THE STAR

Modification 14 | Responses to Stakeholder
Comments on Transport Issues

2 March 2017

3 ASL - HOTEL PORTE COCHERE  
1:100

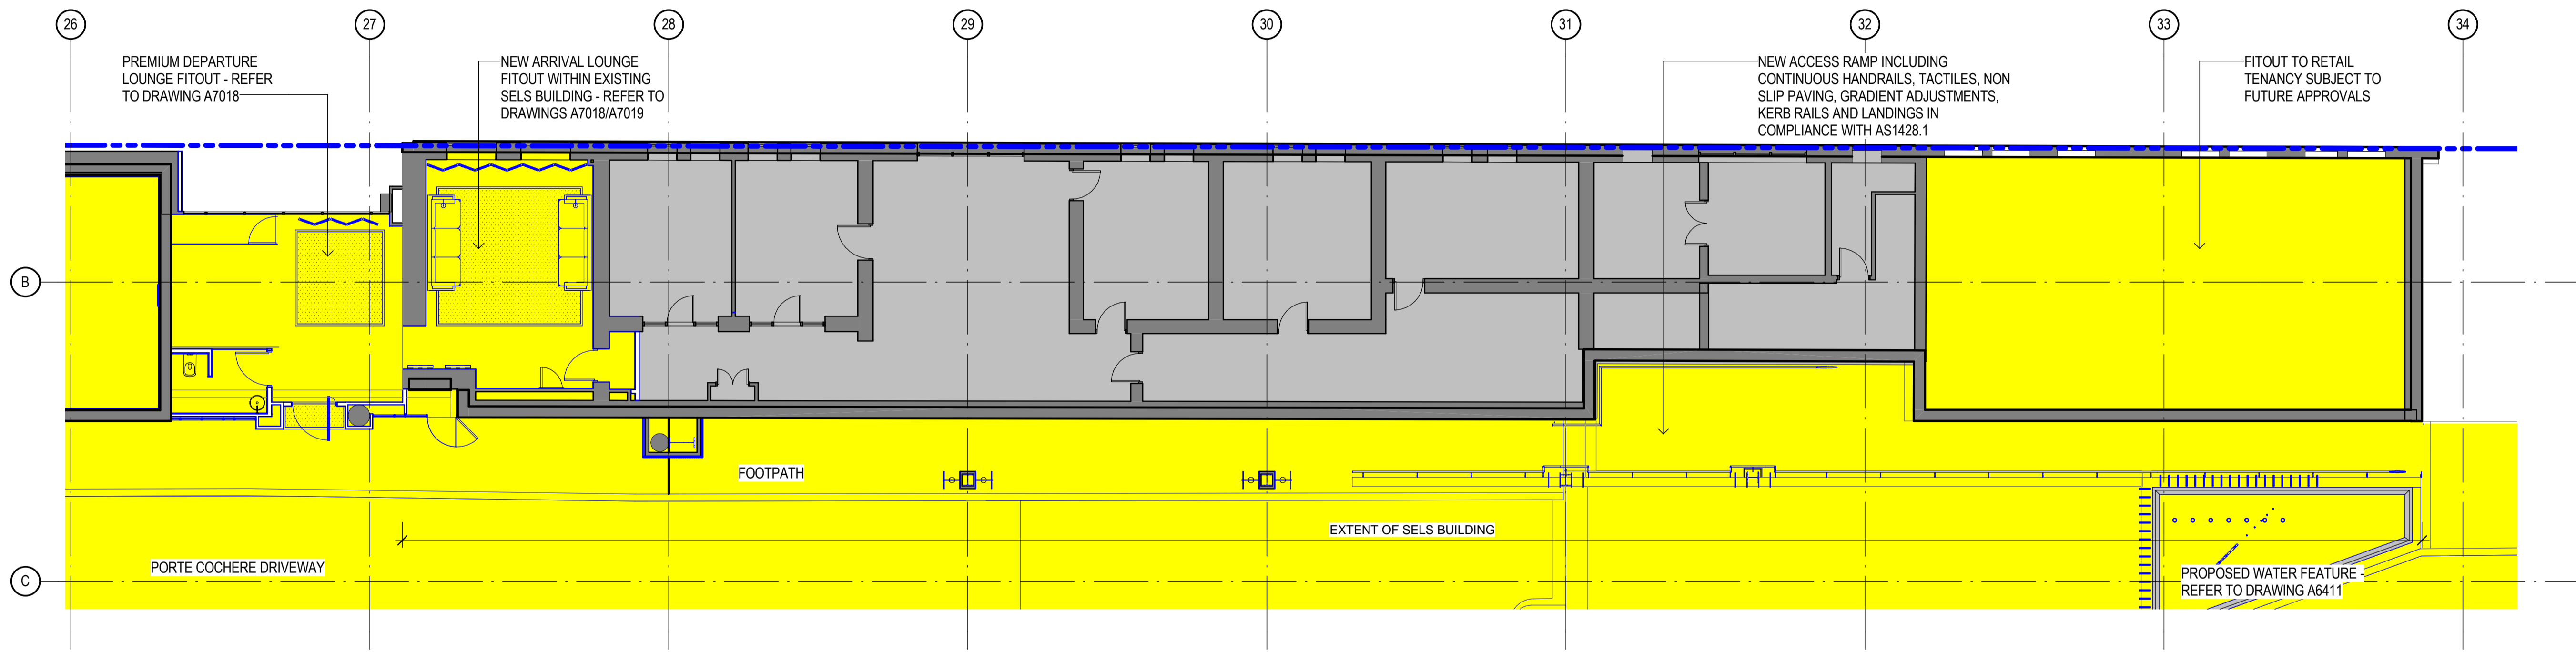
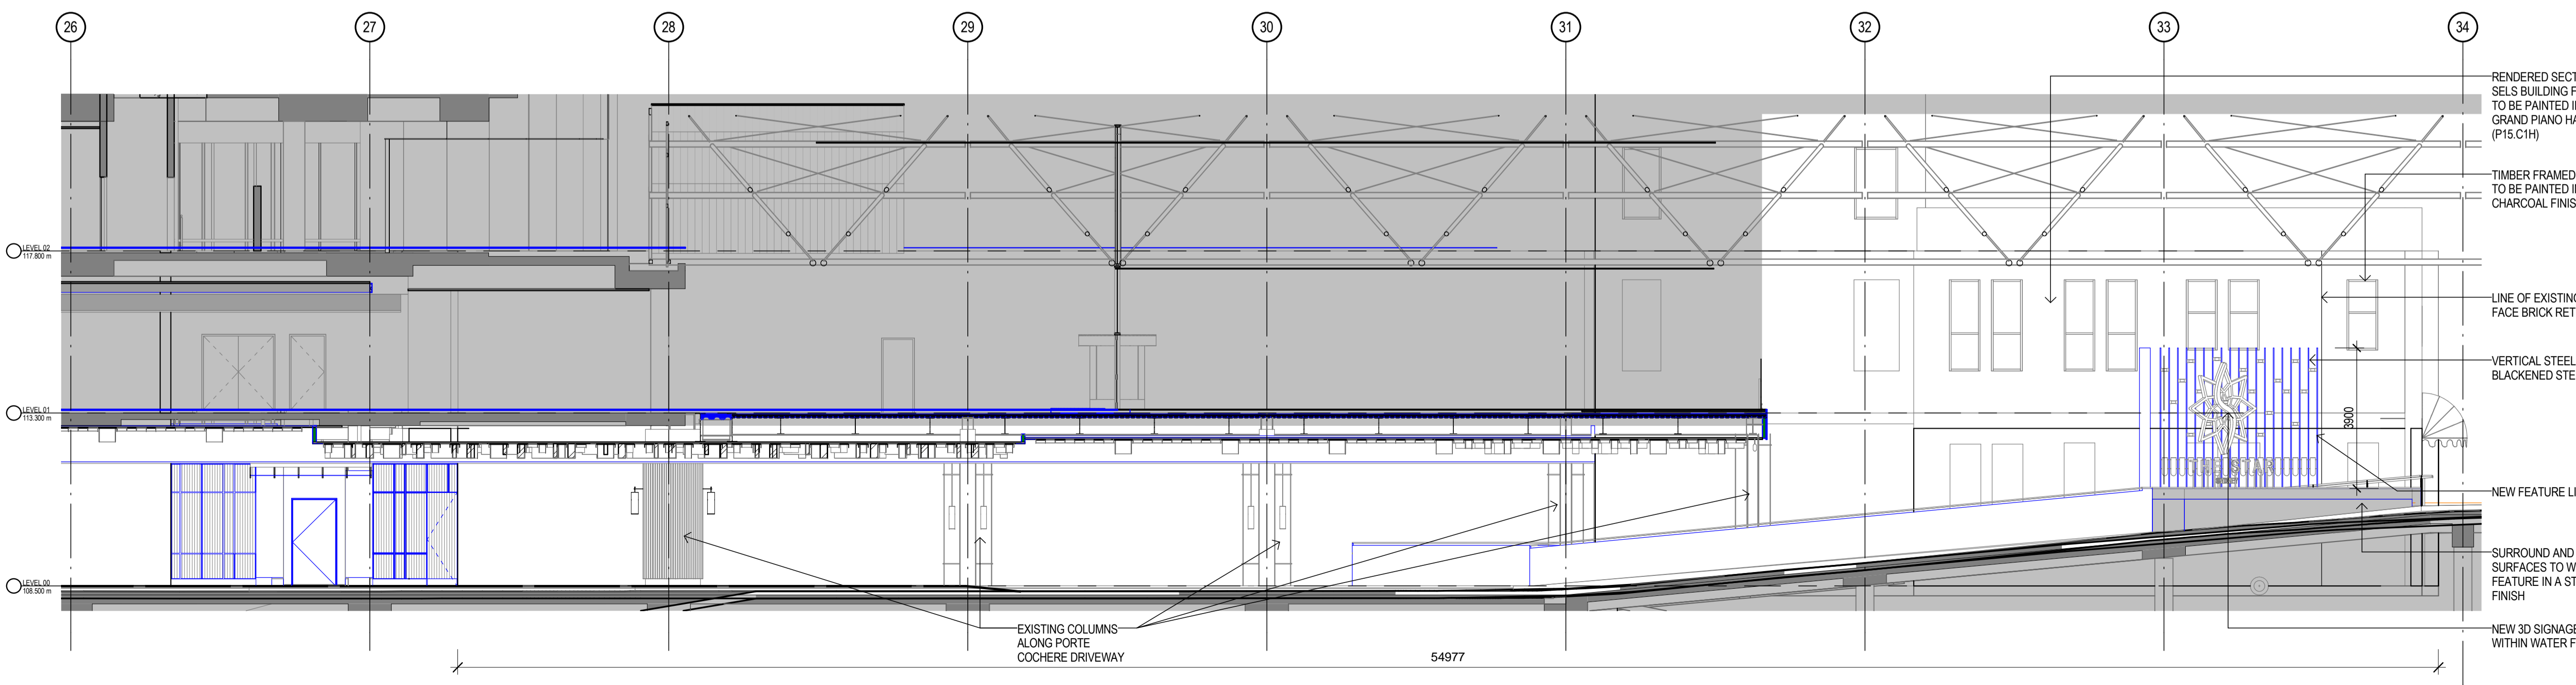
“..details how the redesigned Port Cochere will achieve the following:

- *Addresses the existing operation issues; and*
- *Accommodates the forecast increased usage..” (CoS)*

The Modification 14 changes to the Port Cochere will include:

- Modification to the Astral Hotel façade within the Port Cochere adjoining Pyrmont Street and Jones Bay Road. This will relocate all north-south pedestrian movements along the Port Cochere roadway within the safety of the widened building foyer
- modifications to the layout and width of the Port Cochere adjacent to the existing set-down and pick-up areas.

A minimum roadway width of 8.6m will be maintained in the Port Cochere to accommodate two set-down/pick-up lanes 2.8m wide each and a 3.0m wide circulating lane.

Operations in the Port Cochere will not be significantly changed by Modification 14. Taxis, limousines, valet service and hire cars will continue to operate out of the Port Cochere, as they currently do, however, waiting areas for each will become more formalized (refer Figure 8).

The existing pick-up zone immediately outside the Casino entry has been reduced from 3 to 2 spaces, due to the installation of escalators as part of D2015/1515, and will be converted to a taxi drop-off-only zone in Modification 14.

The existing bay outside the Astral Hotel entry will be paved and the lobby façade extended out to improve pedestrian access to the Astral Lobby. This will prevent the opportunity for double parking of valet vehicles, which currently blocks the Hotel entry. The Casino will be increasing its resourcing of valet resources and will monitor resourcing levels to eliminate any potential for back-ups.
